From: Amanda Scholes on behalf of Planning.Responses
Sent: 01 June 2018 09:08
To: Planning Scanning
Subject: FW: Planning Consultation on: A/40/18/OUT

Comments from Greenspace

NOTIFICATION FROM ARUN DISTRICT COUNCIL
Town & Country Planning Act 1990 (as amended)
Town & country Planning (Development Management Procedure)
(England) Order 2015 - Article 5
Outline Consent
APPLICATION **A/40/18/OUT**
NO:
Registered: 29th March
 2018
Site Address: Land North of Water Lane Angmering
Grid Reference: 507459 105141

Outline application with some matters reserved for the development of up to 525 residential dwellings (Class C3), 3 ha (gross) of employment land (Class B1), public open space, play areas, access, associated infrastructure and landscaping. Departure from the Development Plan.

**Drawing title:** Tree Retention Plan

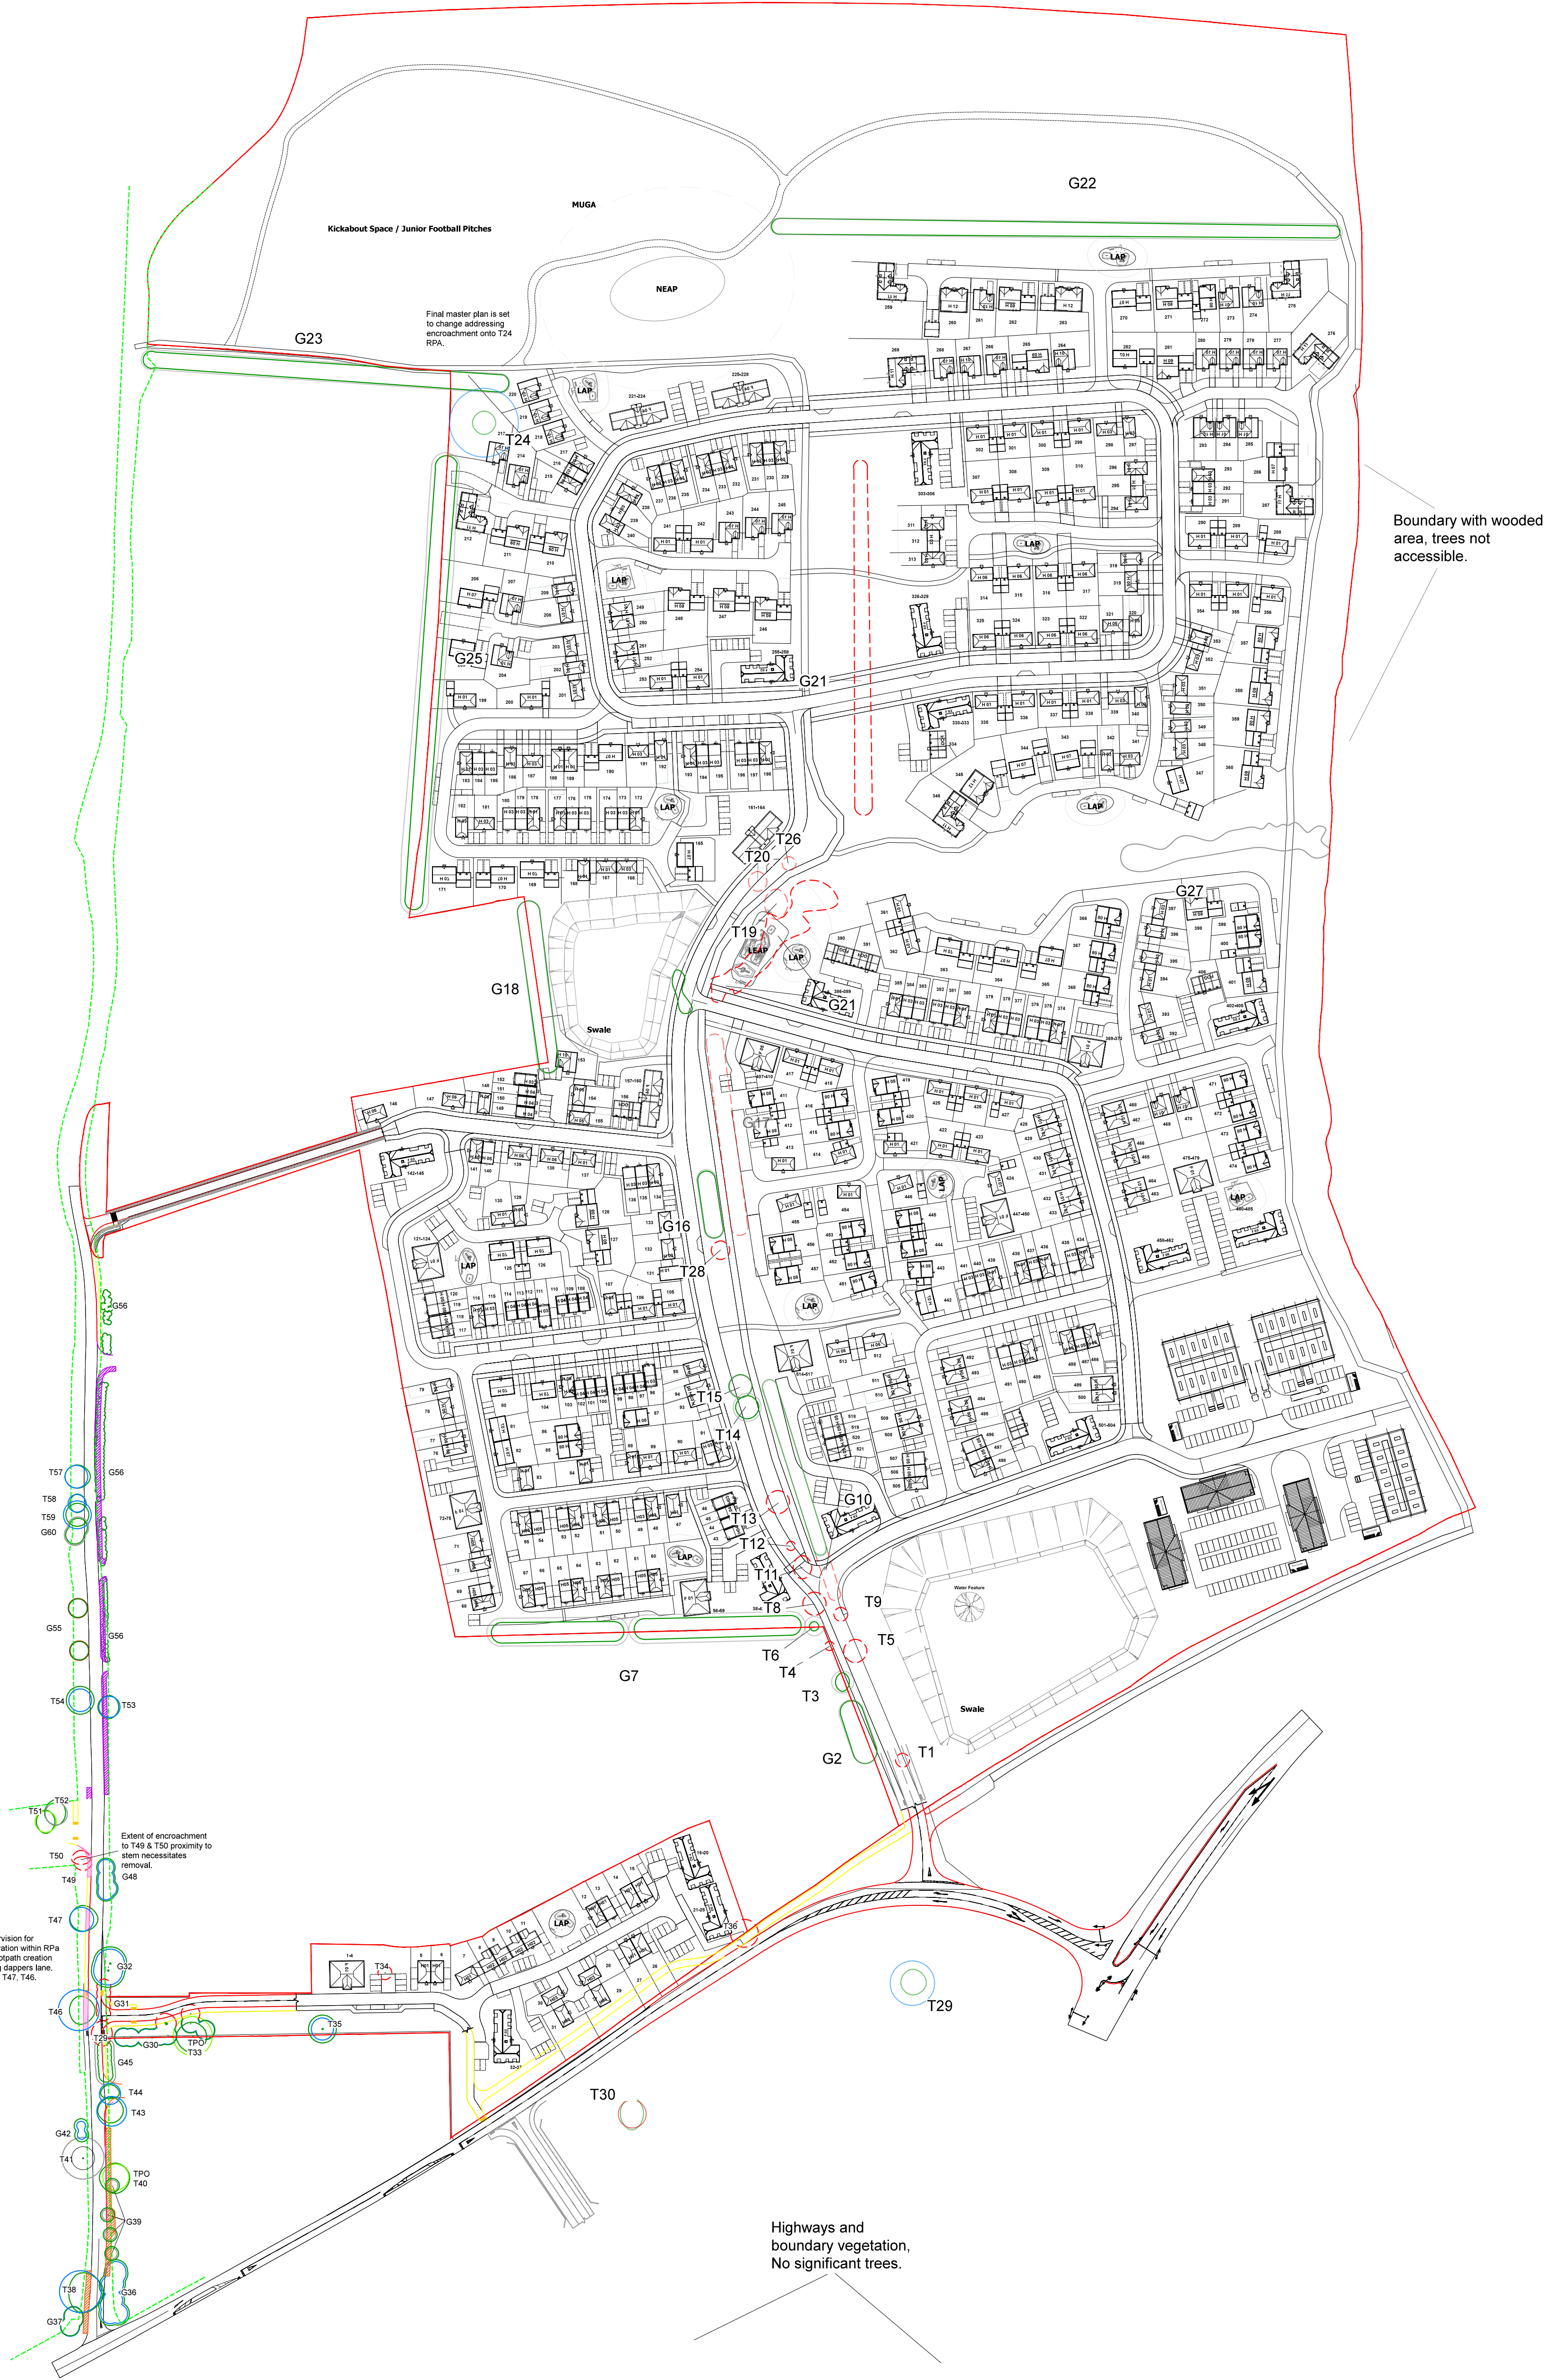
Landscape – Existing trees or vegetation that fall within the proposed or periphery of the development, may provide significant aesthetic impact to the location. Any trees in particular along the boundaries, which adjoin neighbouring properties could provide potential valuable screening and should be protected and retained. Any considered tree works within the site should be agreed with Arun District Councils Tree Officer. Further information concerning the existing hedges across the site and proposed TPO for worthy trees will need to be provided. A tree condition survey of the application site to be provided to highlight the importance of retaining particular trees along with the condition of existing hedgerows locally and their contribution to the landscape should be included. Root protection Areas (RPA) from the tree cover clearly seen to the periphery and in several locations of the site should extend into the development site. Before construction, a tree protection scheme must be in place for these adjacent trees whose root protection areas fall within the construction zone from neighbouring land. This would be required for both construction and heavy vehicle movements for deliveries. This should be in accordance with BS 5837:2012 'Trees in relation to construction'

There is a buffer zone indicated to the east of the proposals abutting Grooms Copse, this is an area of ancient woodland to the east of the proposals and within the SDNP. This buffer zone must be ensured in order that the development does not allow for any detrimental effect on the habitat here. Opportunity however for the connection between the proposed development open space and National Park beyond should be considered.
